**Consultation Response from KC,
Strategic Housing**

**2022/93938 First and Second Floors, Shopping Precinct, New Street and Albion Street,
Huddersfield, HD1 2TR**

**Change of use from A1 (business retail and storage) to C3 (residential) 18 studio flats at first
and second floors and external alterations**

Date Responded: 1st November 2023

Proposed Second Floor Plan

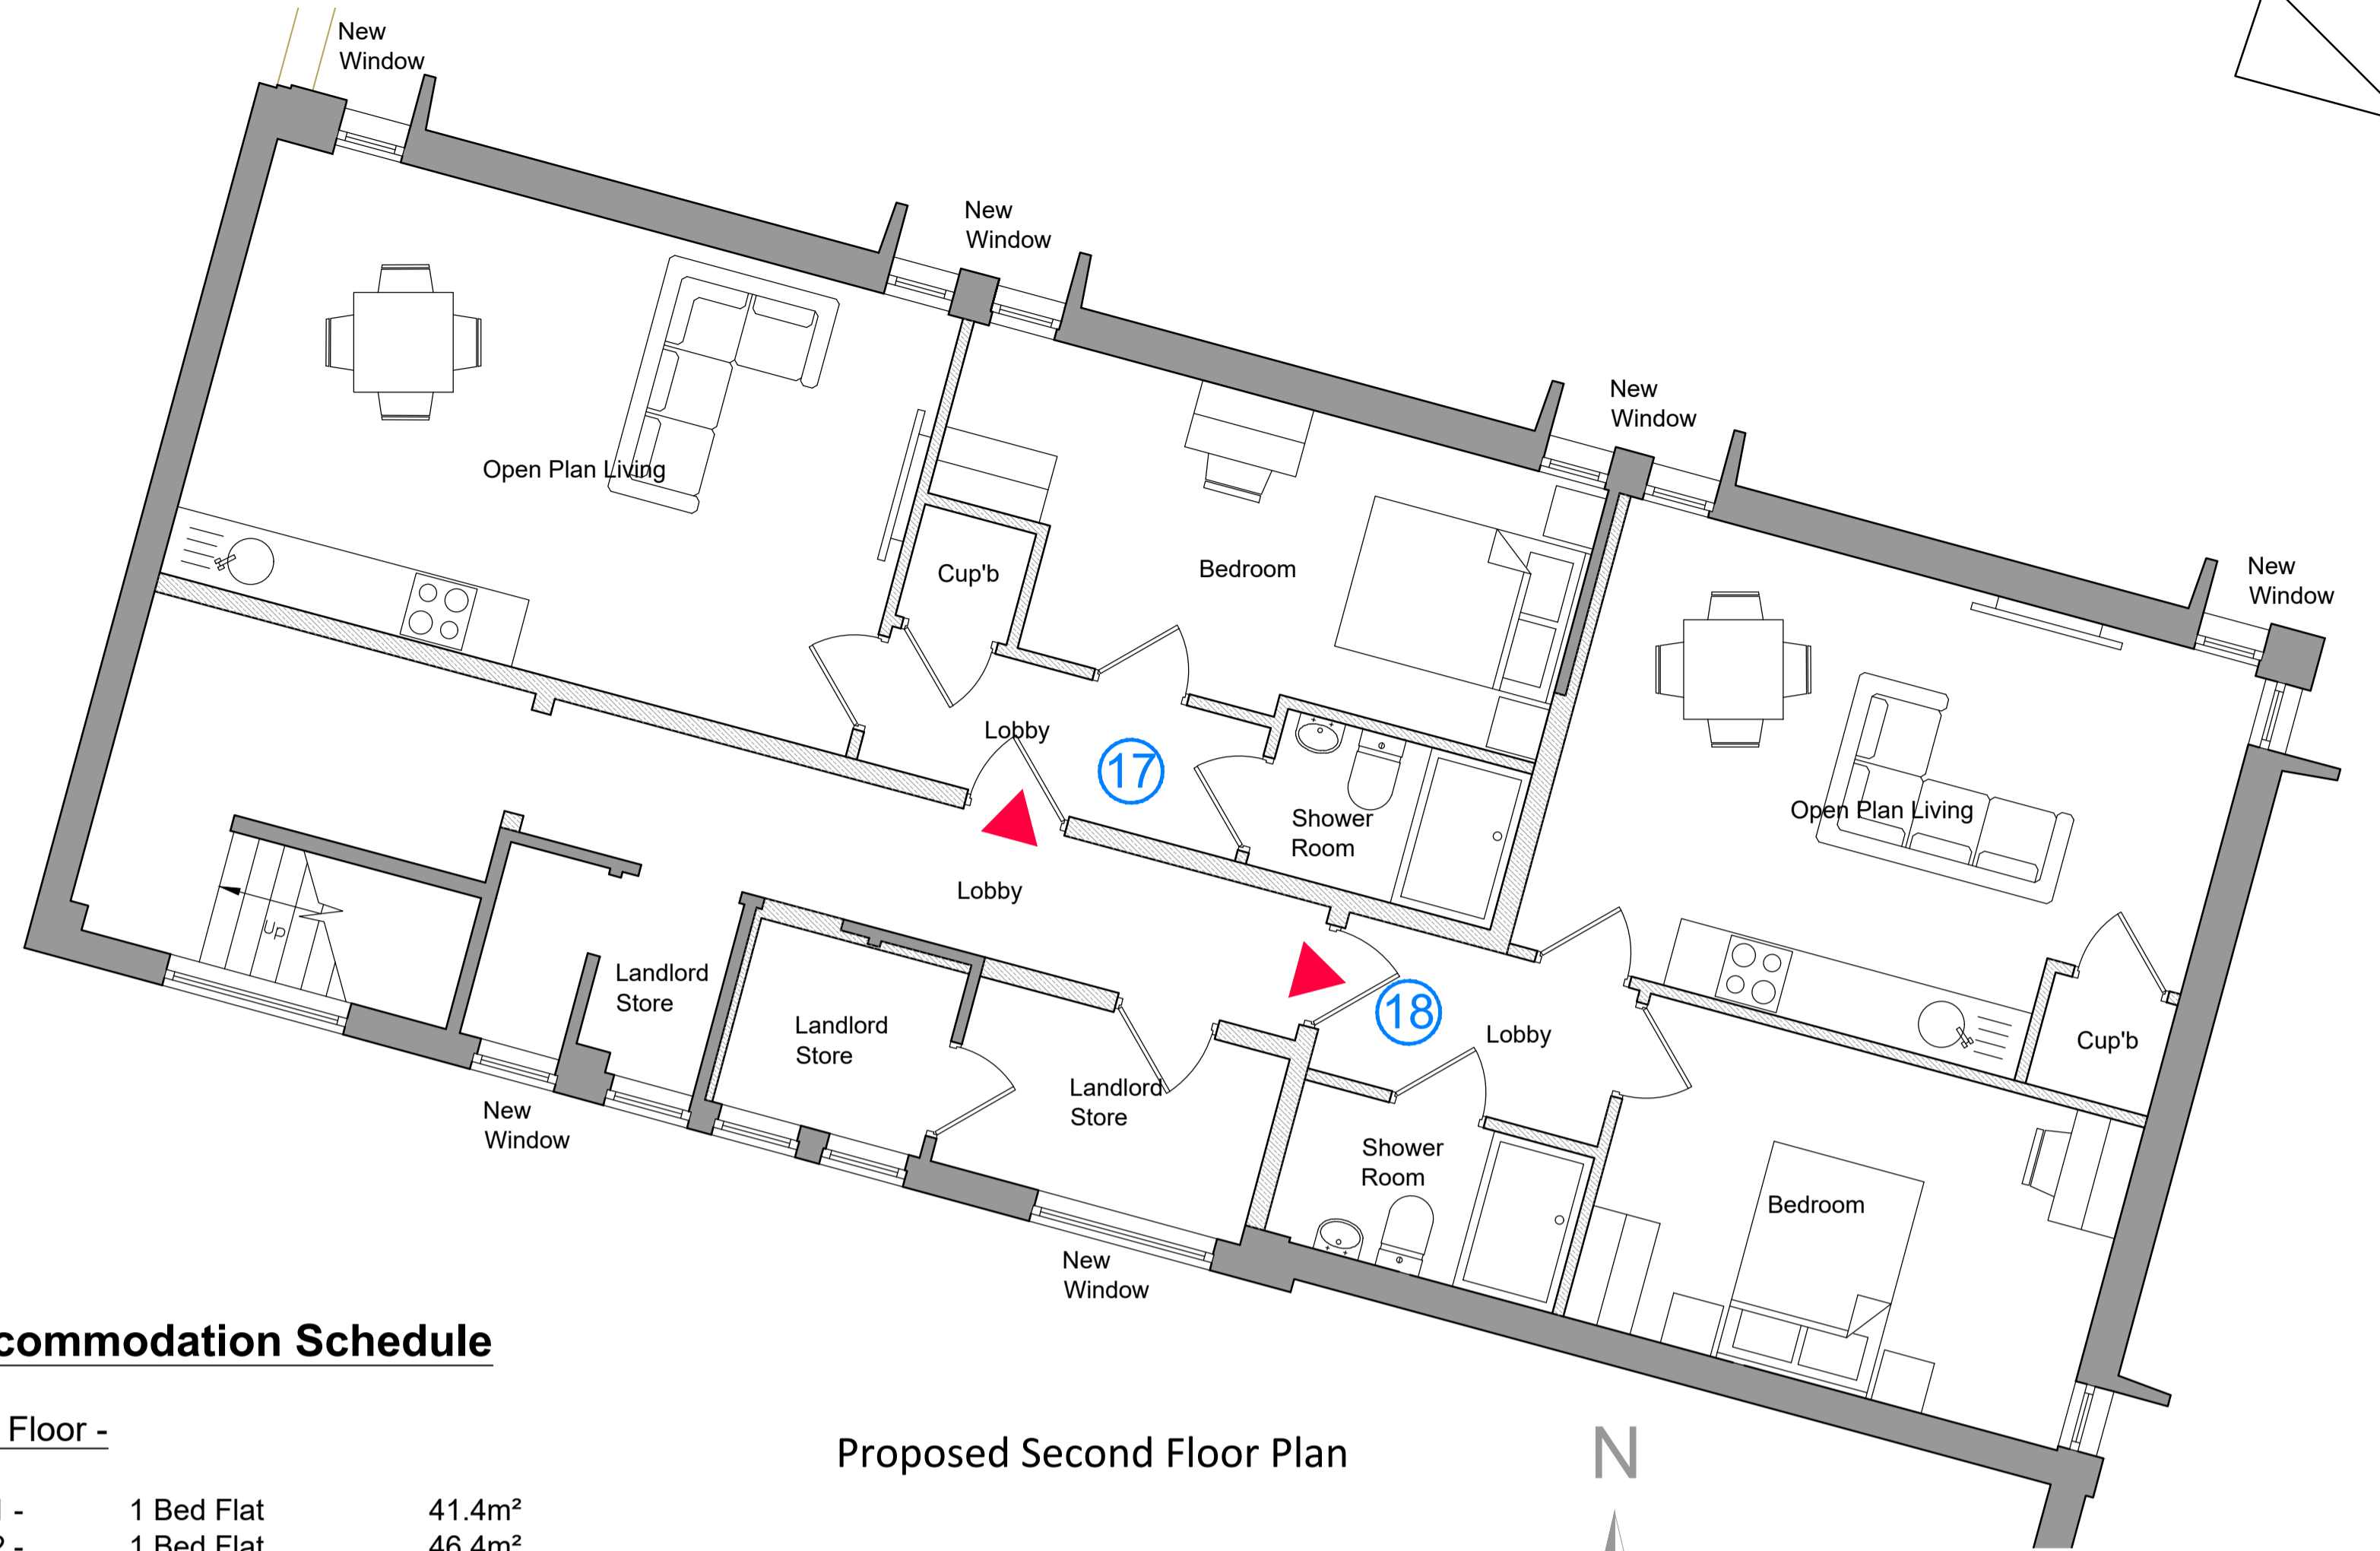
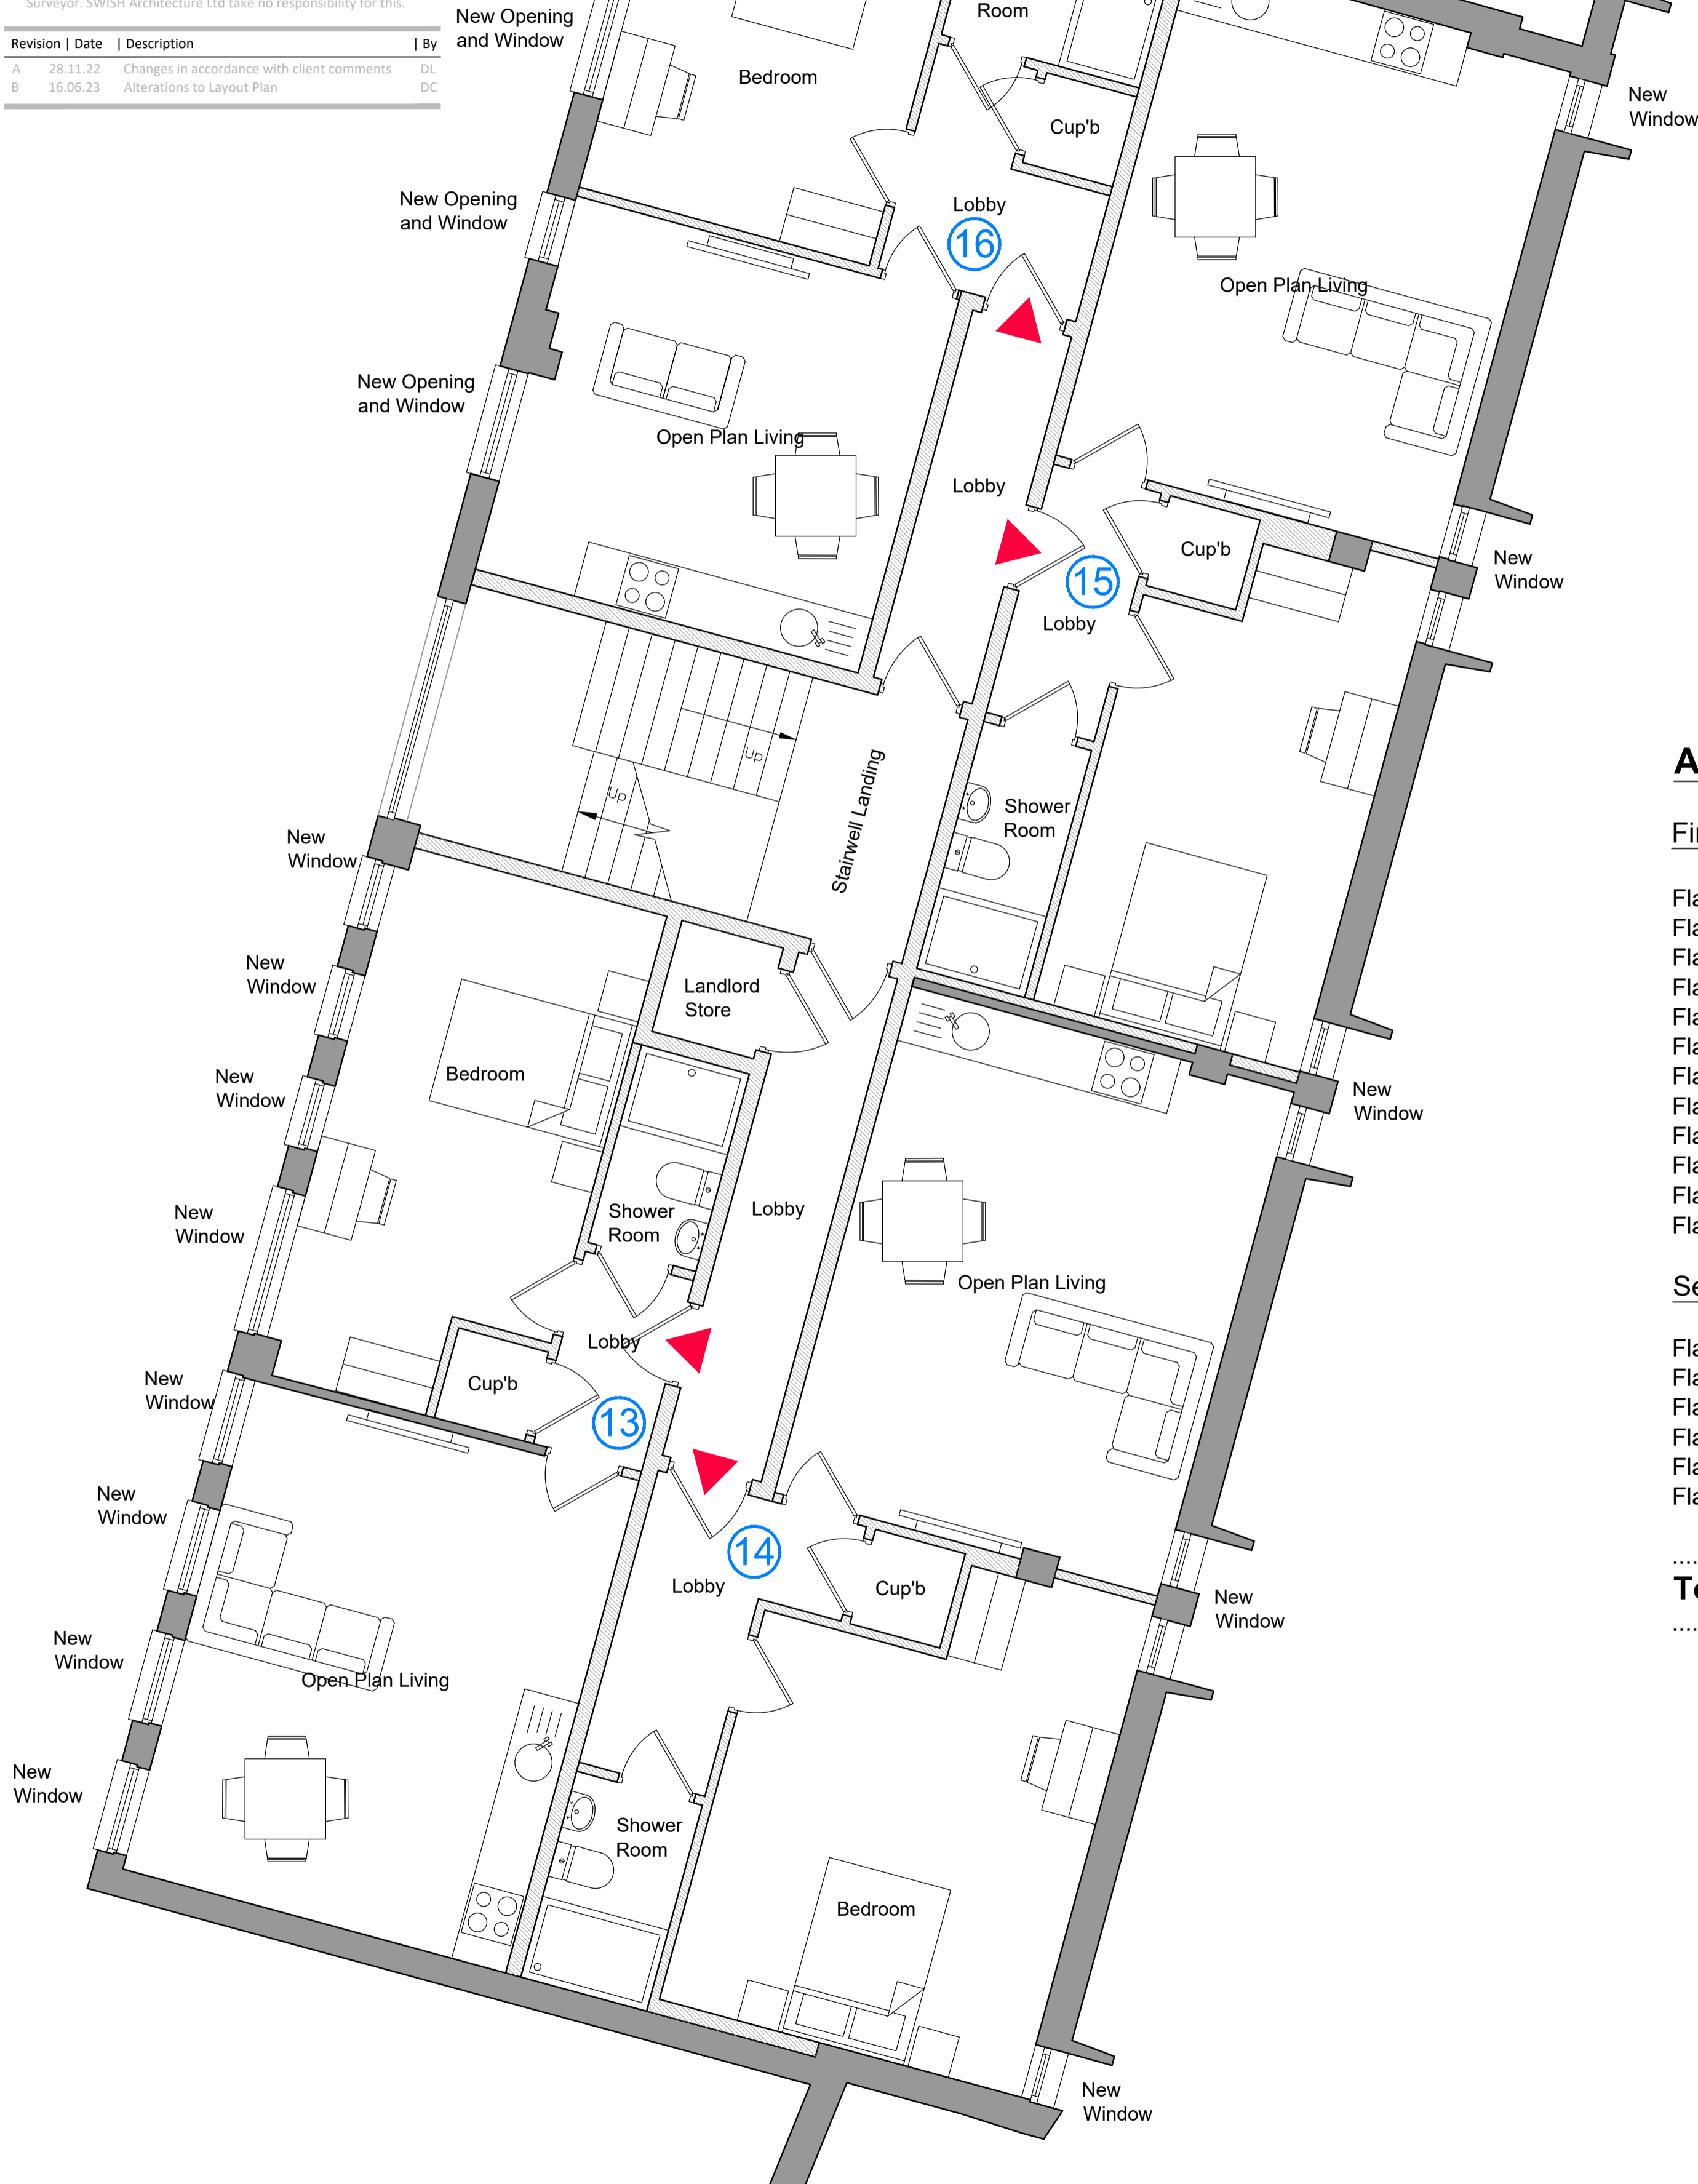
Type: The applicant has amended the total units of this development from 34 to 18 units. The applicant proposes a mix of 15 x 1 bed flat and 3 x studio flats. This proposal still does not meet the Council's aims to diversify the housing mix in Huddersfield Town Centre by providing a mixture of housing type. A more appropriate provision would be a mix of 1 and 2-bed properties.

Nationally Described Space Standards (NDSS): NDSS guidance states that one person with one bedroom should have a minimum floor space of 39 square metres, or 37 square metres if the dwelling has a shower room instead of a bathroom. The plans for this application for the studio flats and 1 bed properties are stated in the range of 37 square metres to 55.2 square metres. The plans show all dwellings to have a shower room. Therefore these units now meet the minimum requirements of the nationally described space standard if all dwellings are for one person with one bedroom. If they are intended at 1b2p dwellings, the minimum space standard increases to 50 square meters. Strategic Housing recognises that this is a significant improvement upon previous plans.
